REQUEST

Current Zoning: R-8MF (CD) (Multi Family Residential, Conditional)
Proposed Zoning: N2-B(CD) (Neighborhood 2-B, Conditional)

Approximately 23.37 acres located north of Neal Road, east of Catalyst Boulevard, and south of IBM Drive.

The petition proposes a residential community of up to 73 multi-family attached (townhome) dwelling units and up to 324 multi-family stacked dwelling units on vacant land. The petition contains an affordability component.

RZ-1.0

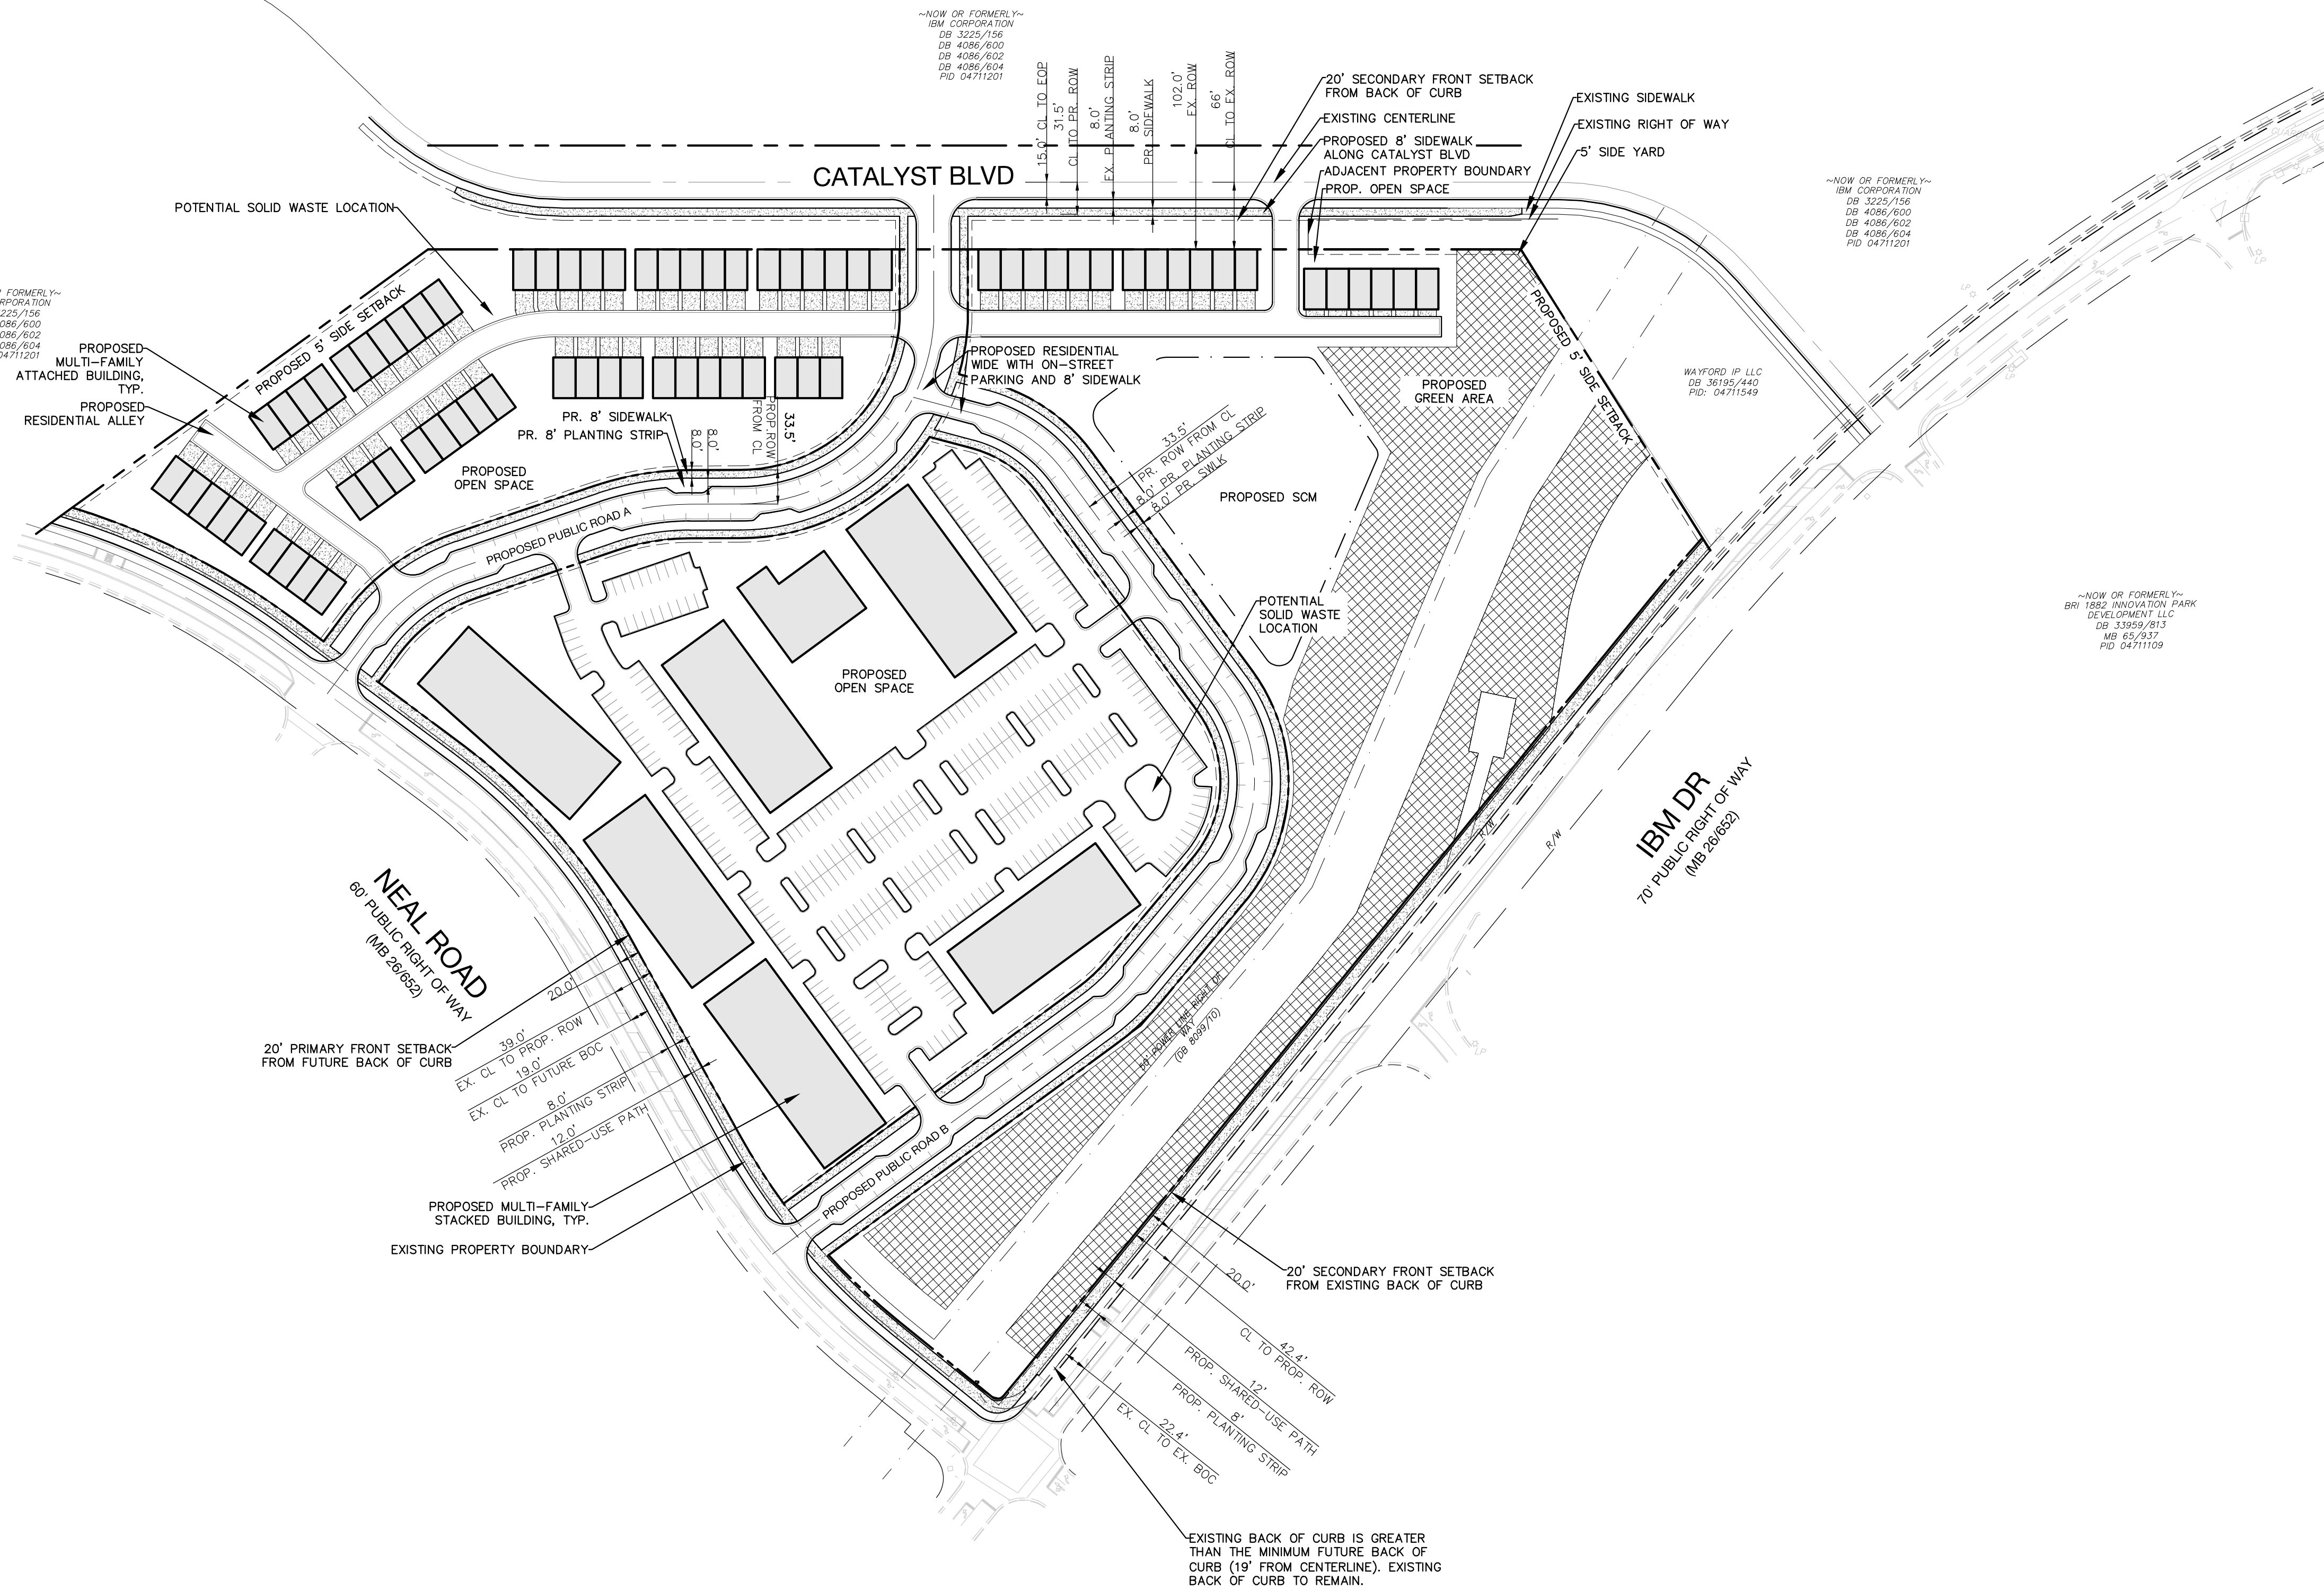
1. Label and dimension the curb and gutter from the centerline for each road on the site plan.
2. Add conditional note to provide a minimum of 50-feet of ROW from the centerline of IBM Drive to accommodate the future right turn lane. Some of the ROW can be placed in an SUE. This ROW will allow for a right turn lane to be constructed at the signal which will drastically increase the functionality of the intersection.

RZ-2.0

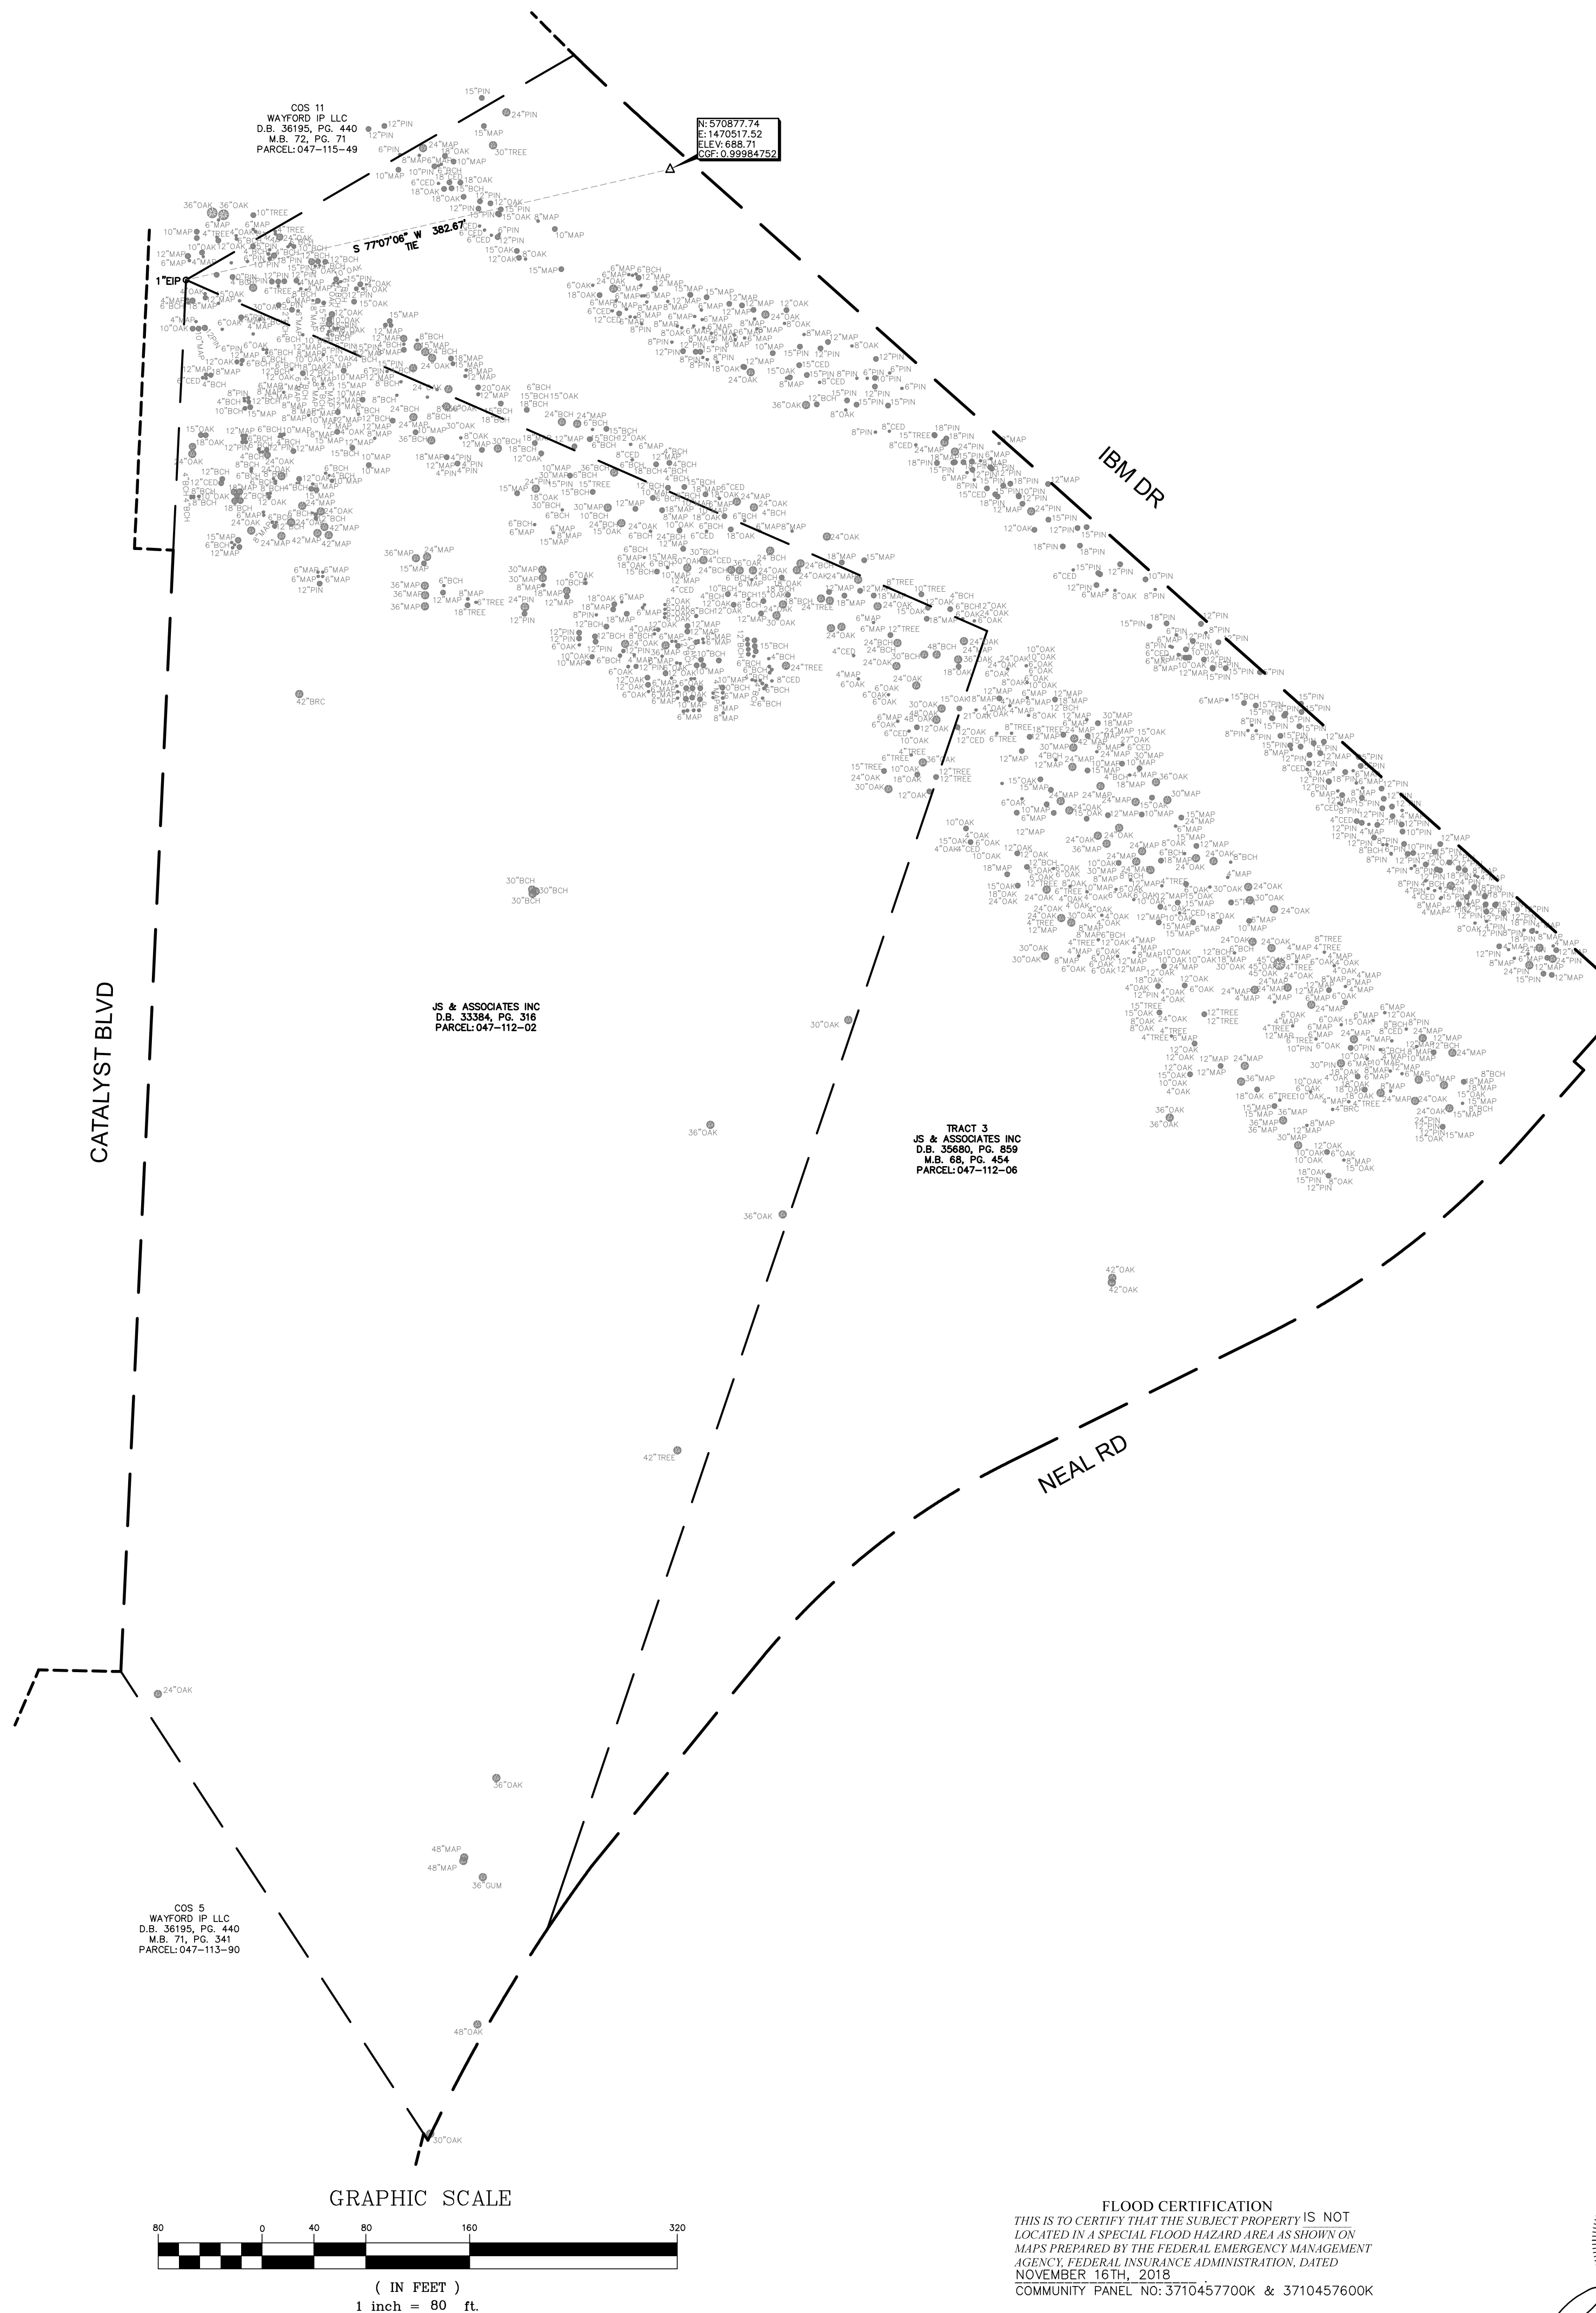
3. Provide greater proportionality in the attached multi-family building forms by decreasing multi-family stacked units and incorporating a mixture of building types.
4. Provide prescriptive standards for each open space element that will be utilized.
5. Consider adding a limit to the number of 6-unit buildings.
6. Provide a minimum dimension for stoops.
